Please ask for: Mrs D Johnson
Email: daun.johnson@arun.gov.uk
Telephone: 01903 737762
Our Ref: WA/58/21/PL
Your Ref:
Date: 23rd June 2021

Application for Planning Permission

Development: The removal of outdoor storage, including caravan & polytunnels, the erection of 7 workshop units comprising of 12 offices & 3 commercial units, associated parking, drainage and turning spaces. This application is in CIL Zone 3 (Zero Rated) as other development

Location: Brookview Nursery Eastergate Lane Walberton BN18 0BA

Proposed Block Plan
Scale 1:500

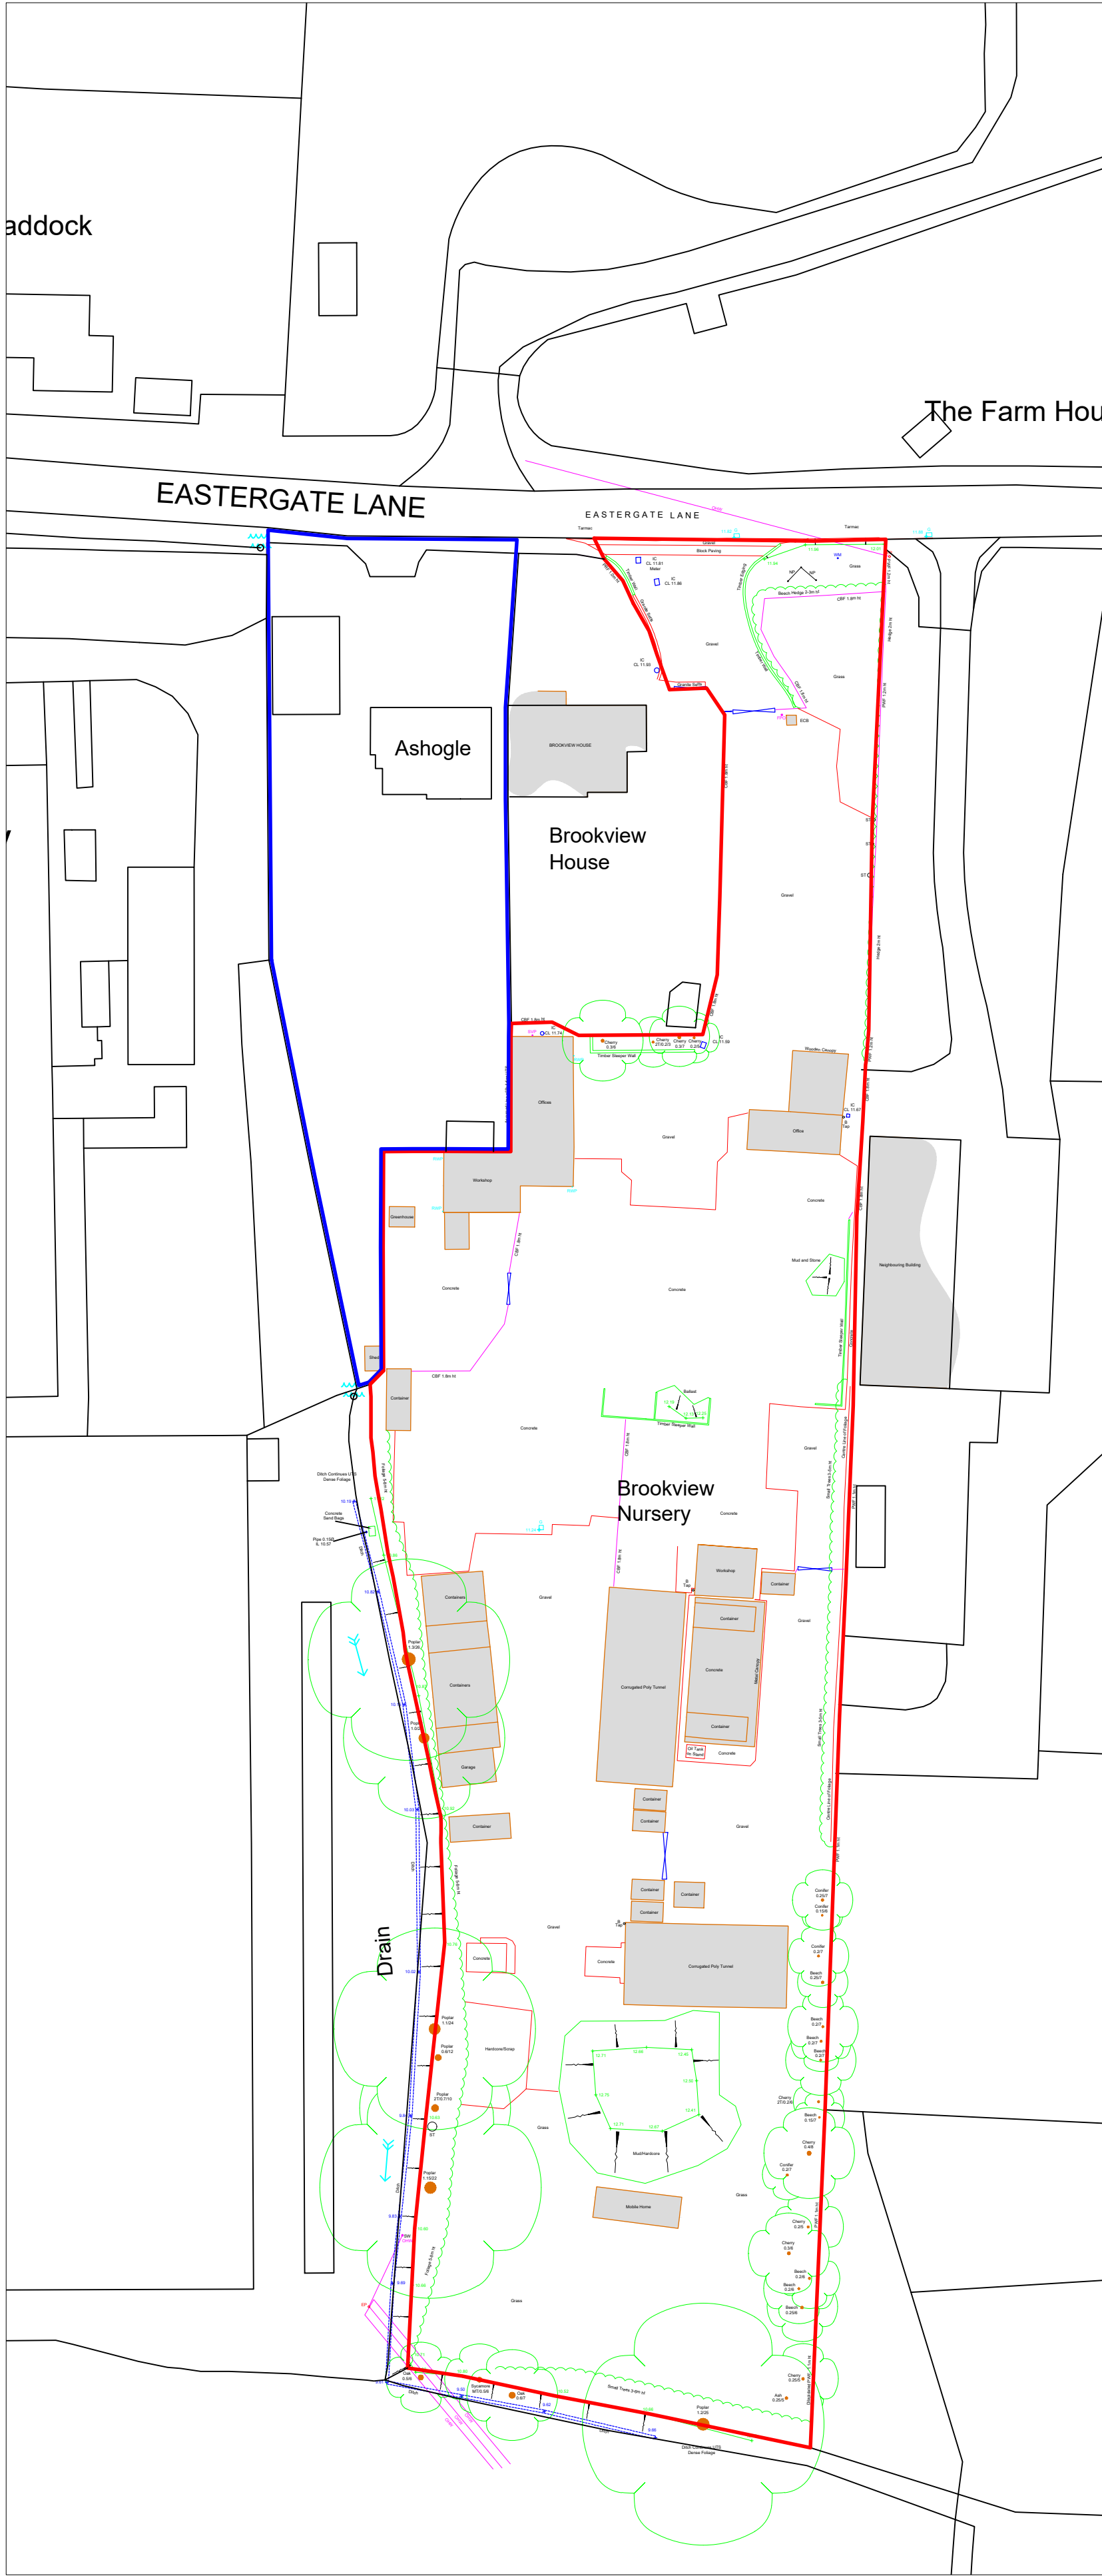
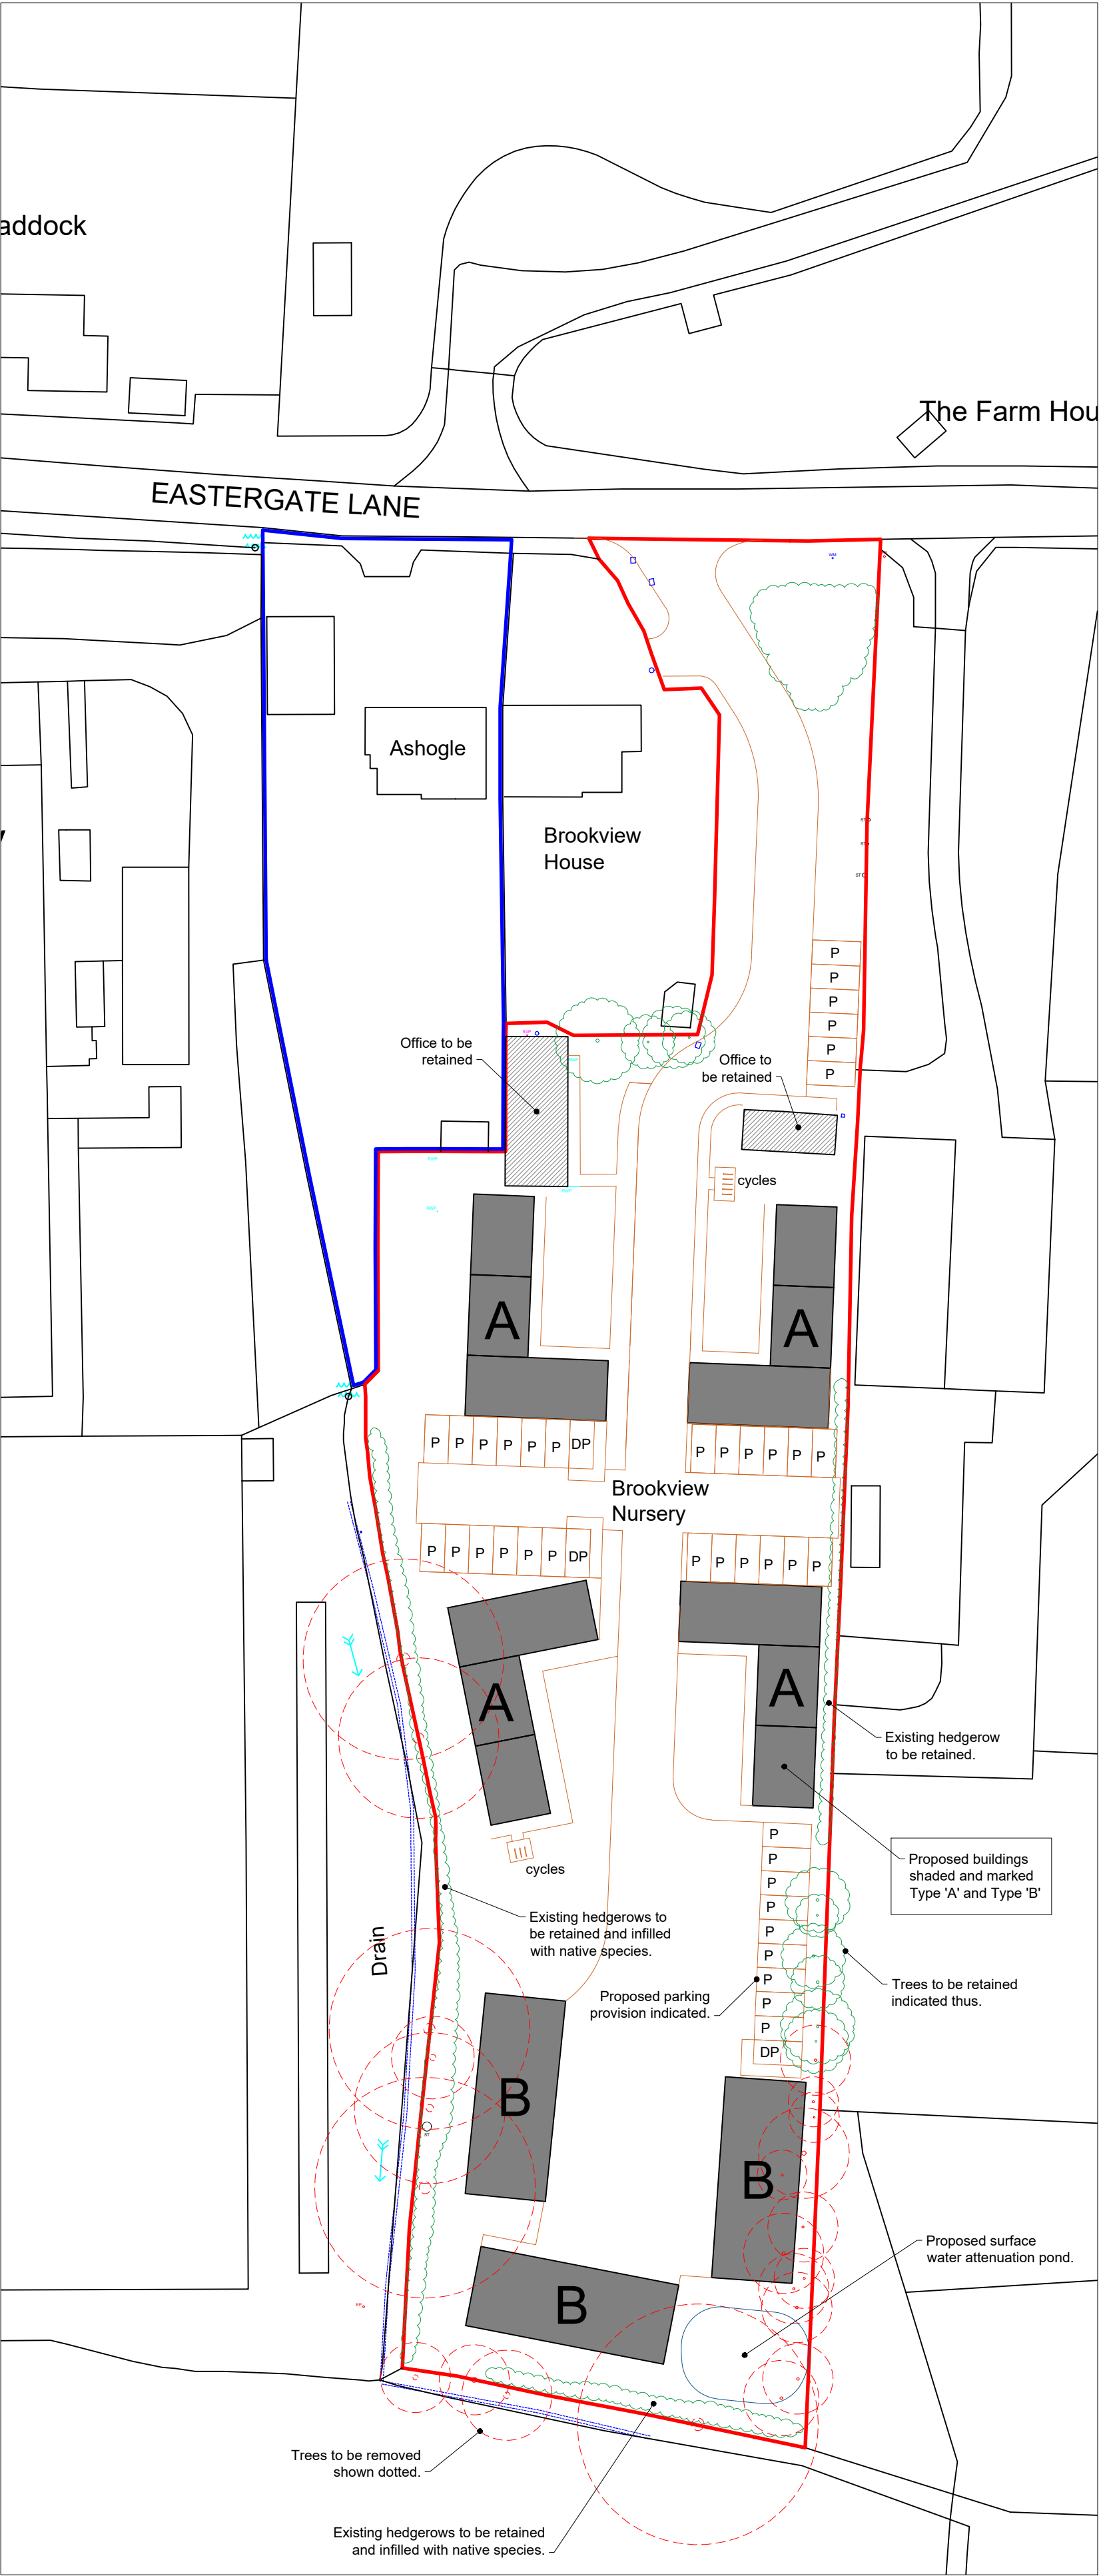
Block Plan

Please show the proposed new access (as indicated on the application form).
CIL Additional Information Form
